Item No.	Report of the Head of Development Management and Building Control	
Address:	28 COLUMBIA AVENUE RUISLIP	
Development:	Conversion of roof space to habitable use to include a rear dormer with juliette balcony, 1 front roof lights and conversion of roof from hip to gable end	
LBH Ref Nos:	59385/APP/2023/3377	
Drawing Nos:	Location Plan B189002-02- 1100 Rev A B189002-02- 3100 Rev A B189002-02- 3000 Rev A	
Date Plans received:	23-11-23	Date(s) of Amendments(s):
Date Application valid	23-11-23

Planning permission is sought for the conversion of roof space to habitable use to include a rear dormer with juliette balcony, 1 front roof lights and conversion of roof from hip to gable.

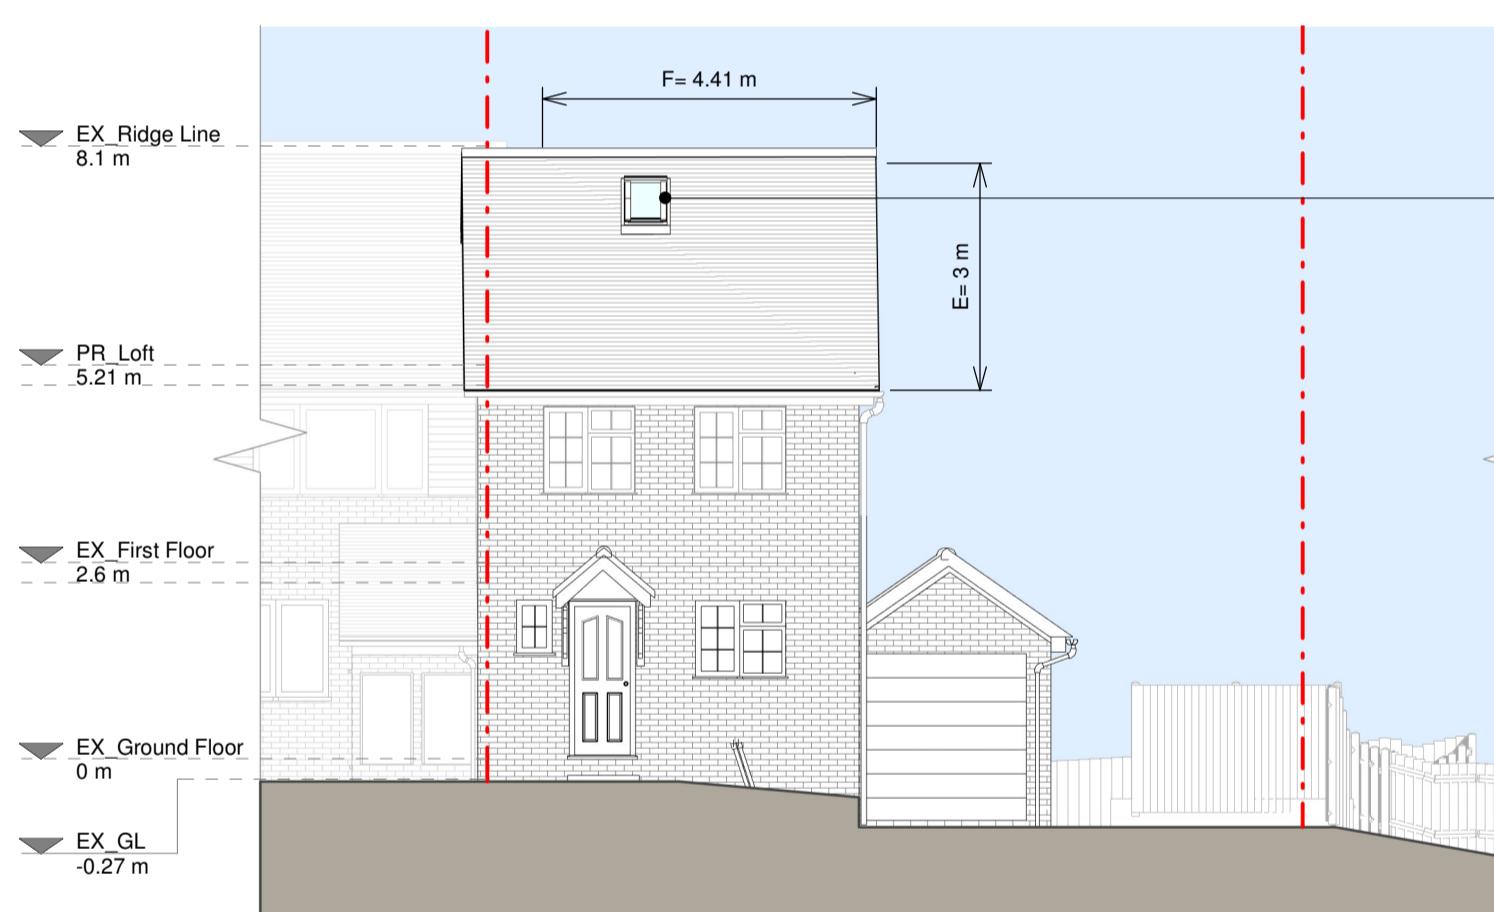
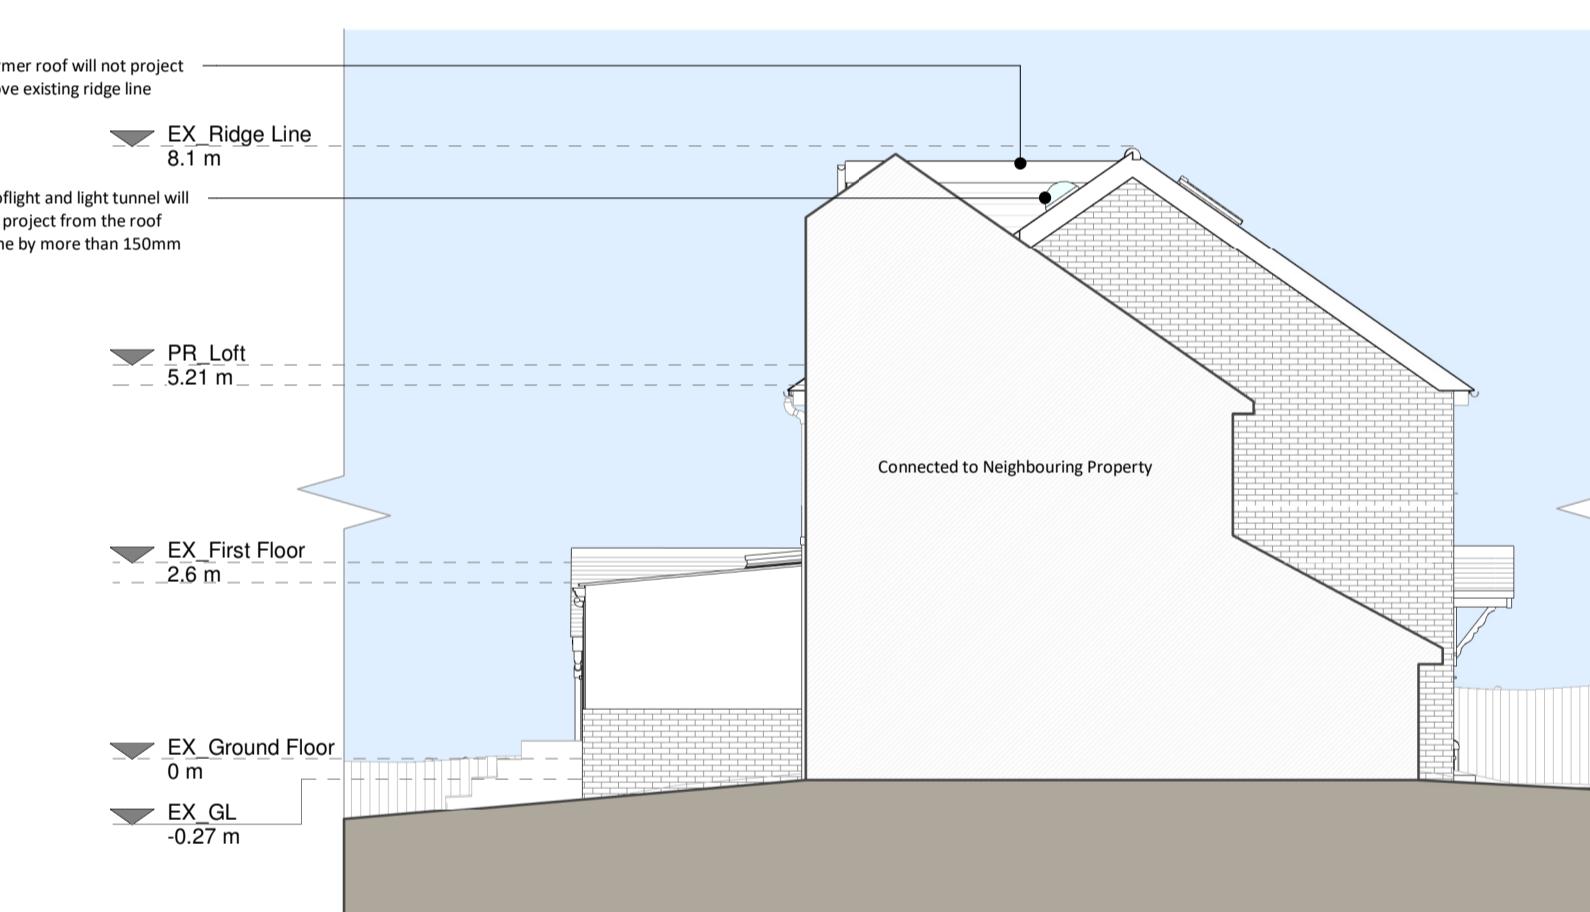
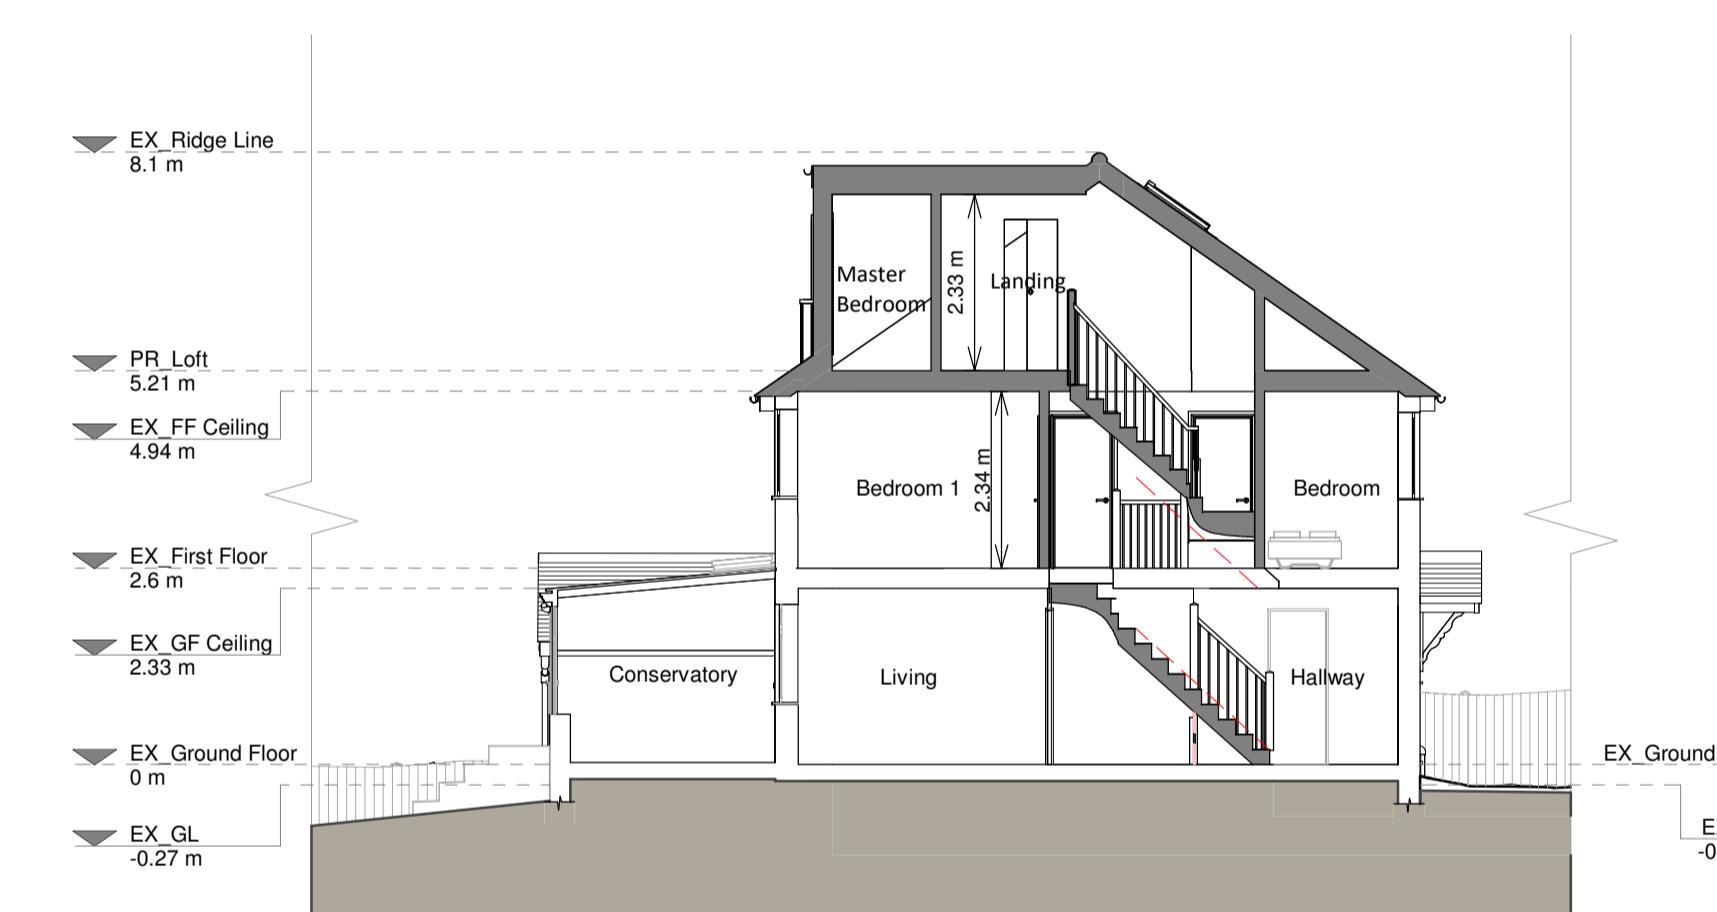
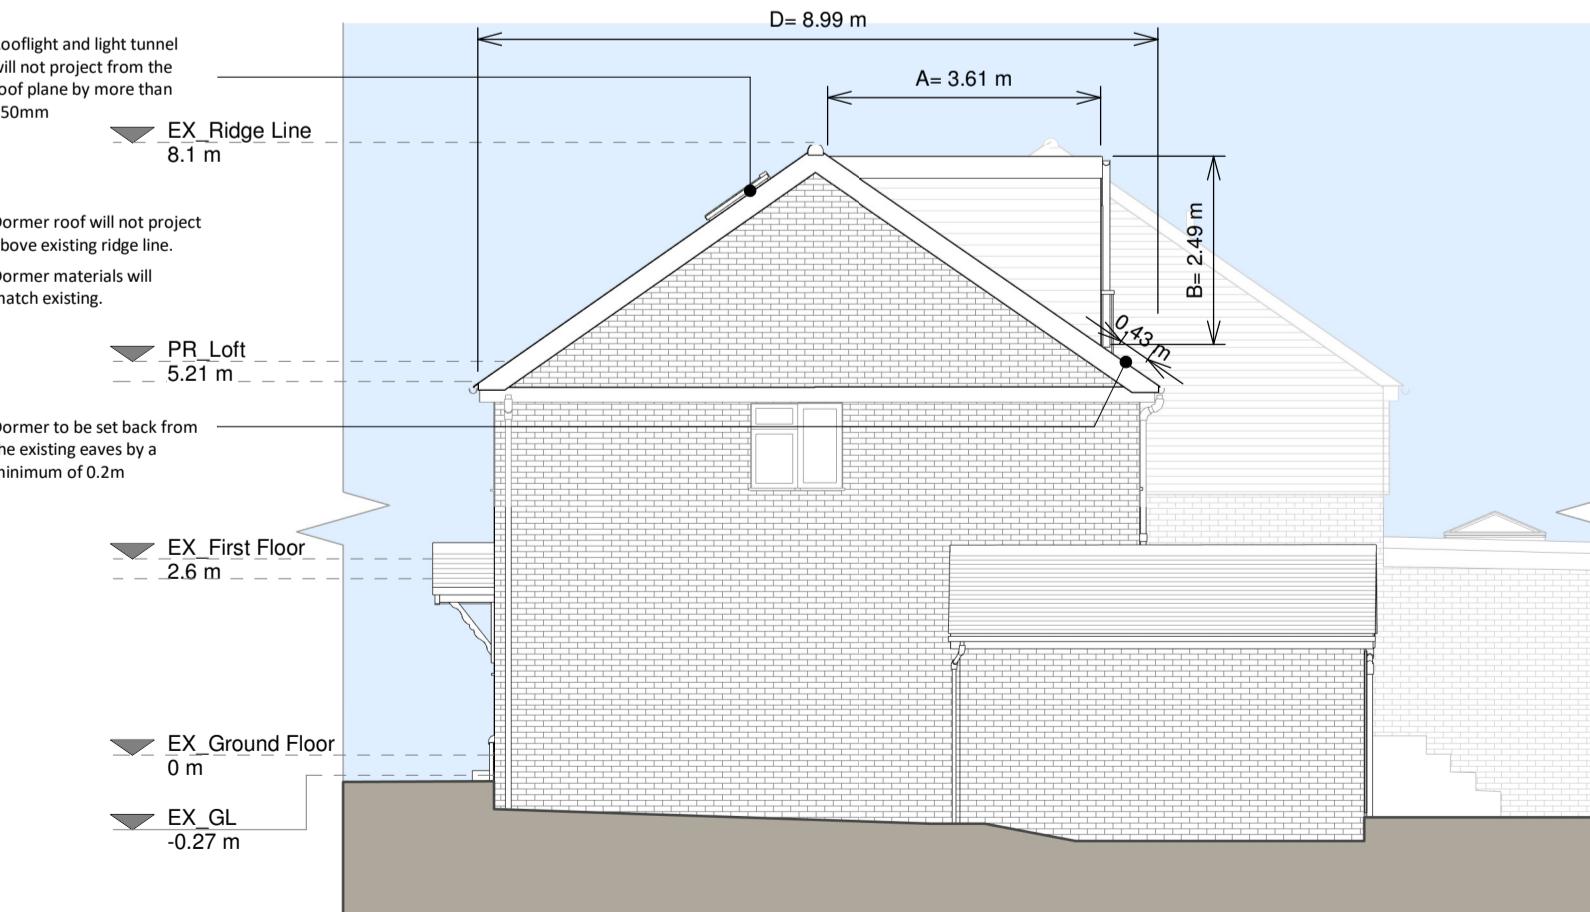
The application proposes a hip to gable conversion with a rear dormer. The proposed hip to gable extensions would add substantial bulk to the roof of the property which would be visible from Columbia Avenue. The proposed hip to gable would visually unbalance the appearance and

proportions of the terraced property. It is acknowledged that the associated neighbouring end of terrace dwelling has retained its original hipped roof and the proposal would have an adverse impact on the character and appearance of the host dwelling and the street scene. The proposed hip to gable, would result in an unbalanced and non-symmetrical gabled roof which would appear completely at odds with the symmetry currently experienced at the site. It is acknowledged that the adjacent terraced features two gabled ends, however this would not mitigate the impact on the associated terraced property.

One of the features of this particular group of terraced properties is that the properties gradually increase in height from north to south, the application property sitting significantly higher than its adjoining properties. The hipped roof allows for a softer appearance in terms of the street scene. The proposed gabled roof would appear bulky and incongruous from the street scene.

The proposed dormer would measure a width of 3.8m, a depth of 3.6m and a flat roof height of 2.5m. The proposed dormer would exceed more than two thirds the average width of the original roof. It would fail to appear subservient to the existing roof. In this regard, the proposed dormer would fail to comply with Policy DMHD 1.

The proposed hip to gable conversion and rear dormer, by virtue of the inappropriate design, scale, bulk and massing, would appear as a incongruous addition that would fail to respect the original roof form, architectural composition of the original dwelling, thereby visually unbalancing the appearance and the proportions of the group of terraced properties as a whole. Consequently, the proposal would cause significant harm to the character, appearance and visual amenities of the host property and the surrounding area, contrary to Policy BE1 of the Hillingdon Local Plan: Part One- Strategic Policies (2012), Policies DMHB 11, DMHB 12 and DMHD 1 of the Hillingdon Local Plan: Part Two - Development Management Policies (2020), Policies D3 and D4 of the London Plan (2021) and Chapter 12 of the National Planning Policy Framework (2023).
